## **GLEBE ROWING CLUB INC.**

13 November 2019

Your reference: **SSD-8924**

### **Concept development application for the New Fish Market & Stage 1**

**Diagram : Existing Blackwattle Bay / Rozelle Bay Rowing Course**

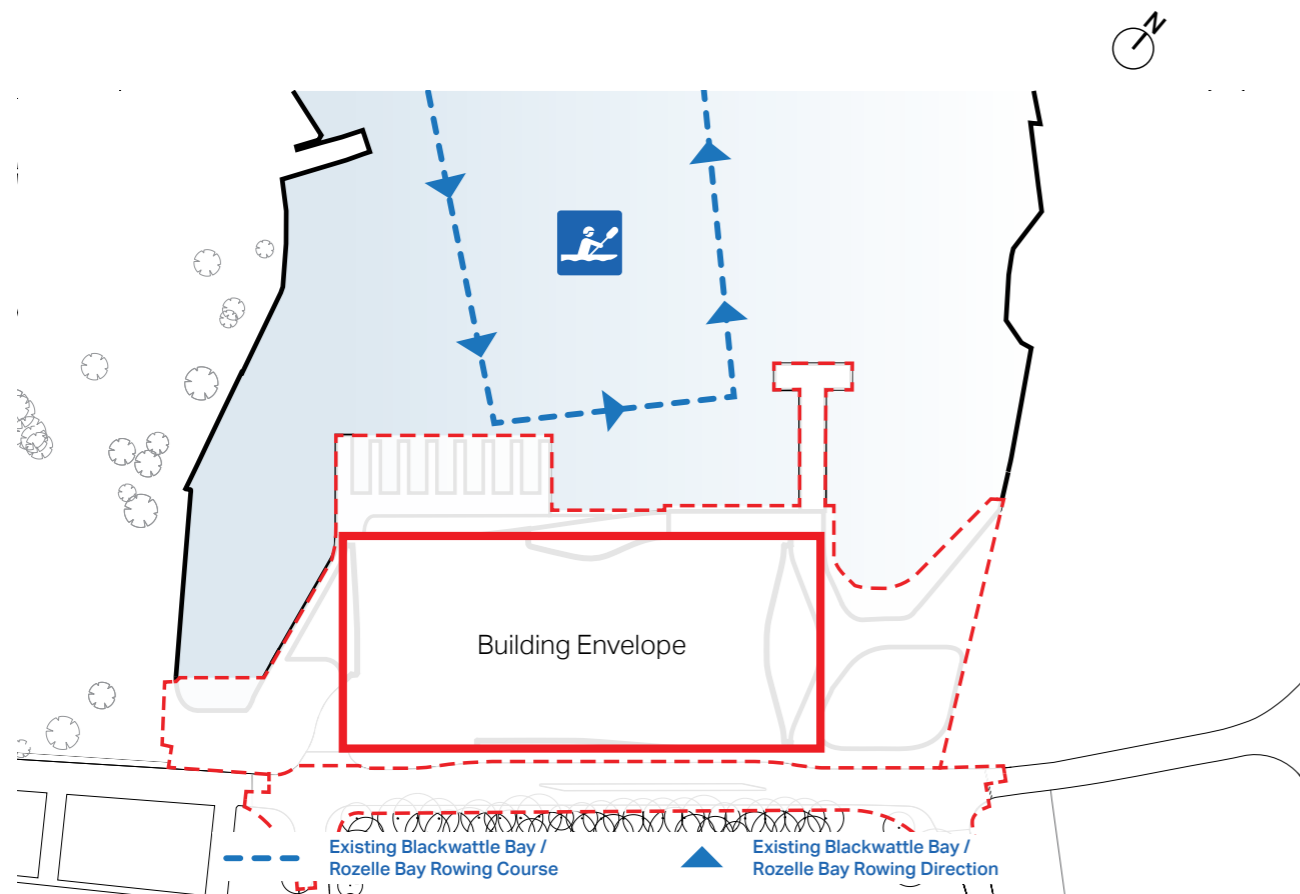
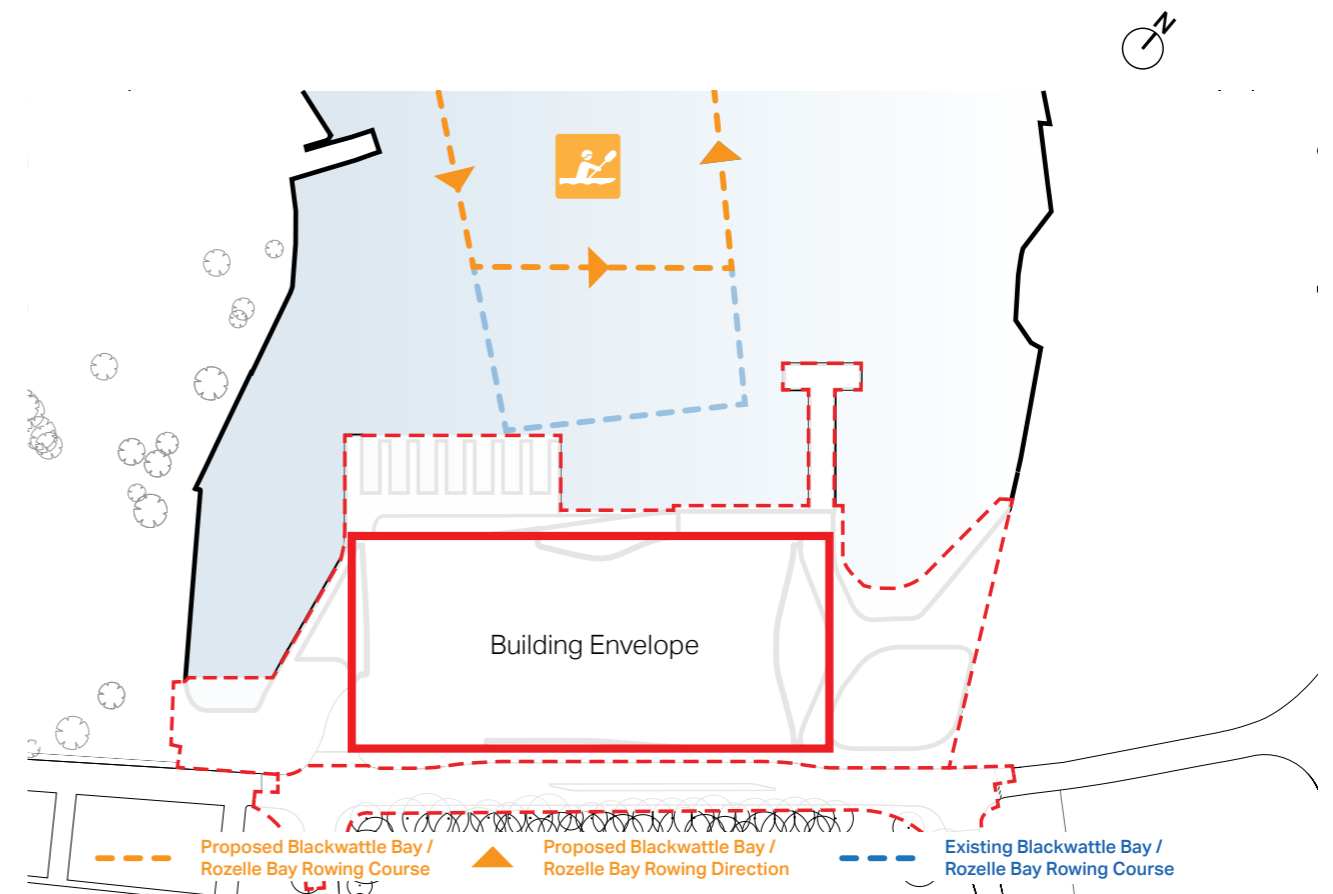
The current analysis of the safety of the planned Eastern Wharf does not reflect: a) correct rowing route and lanes; b) the turning circle of rowing boats at the head of the Bay; or c) the turning circle of the proposed ferry at the end of the pontoon.

To accommodate for the Eastern Wharf’s encroachment onto the Bay, the EIS, and the supporting Navigational Impact Plan propose a solution to modify the rowing route by 45 metres to maintain a safe distance between turning boats and vessels docking at the wharf.

In fact, with the Eastern wharf situated as per the design, to maintain a safe distance would require a 70 metre reduction in the rowing course that would be inconvenient and unsafe. This because the NIP:

- incorrectly identifies the correct rowing course length and direction (see Diagrams A and B); and
- fails to factor in the turning circle considerations of rowing and ferry vessels.

The proposed rowing course identified in the NIP is unsafe as it would put rowing boats on course for collision with on-coming traffic as it places:

- rowing boats travelling on the Eastern side, essentially down the middle of the Bay, typically in the same lane as an increased number of motorised craft that typically travel down the middle of the Bay; and
- would have rowing boats leaving the pontoon at right angles to rowing craft coming down the West side of the Bay.

We request that the wharf be shortened by at least 32m to restore the safe distance from the actual turning circle of boats and the wharf.

To maintain the safety considerations accounted for within the design of the current rowing course, the length of the proposed East Side wharf needs to be reduced by approximately 32 metres. This is required to maintain a safe distance from turning rowing boats from the ferry wharf.

**Diagram : Wharf - Recreational And Ferry**

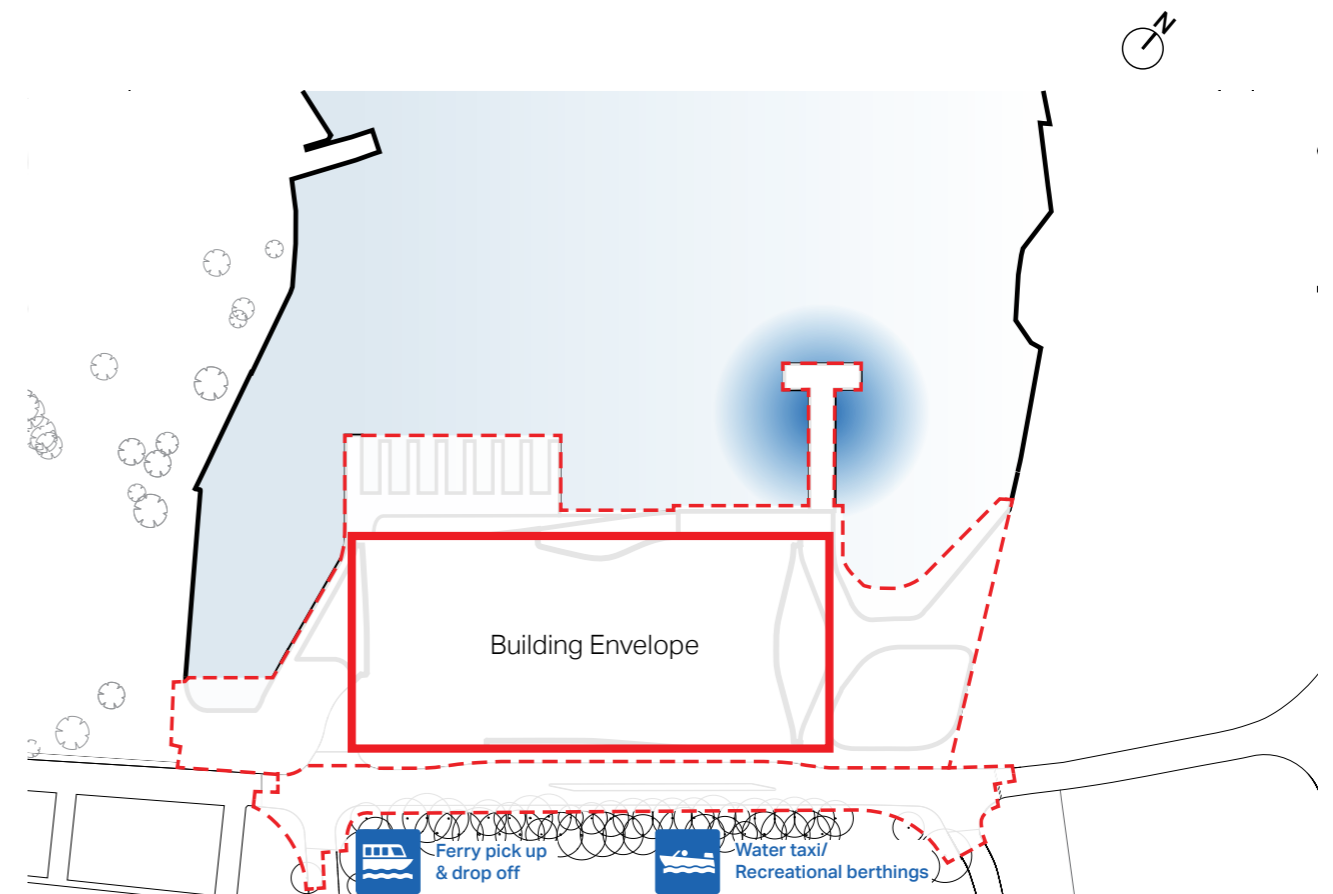
**2. The length of the public wharf on the eastern side needs to be shortened by 32m to ensure it does not create an unsafe turning circle for recreational water traffic.**

The current design includes an Eastern public wharf designed to accommodate motorised recreational vessels and a ferry stop. The proposed wharf structure extends an additional 65 metres into Blackwattle Bay and it is proposed that the current agreed rowing course be shortened by 45 metres to accommodate for the new wharf.

We currently muster and turn where the Eastern Wharf is planned to end. Even with a reduced rowing route, we estimate that our turning circle would put us directly in front of the new wharf. When including ferry services likely to be placed at the front of the wharf, rowing boats would be mustering around 20m from the wharf. By the NIP’s own account, this is an unsafe distance from the Eastern Wharf.
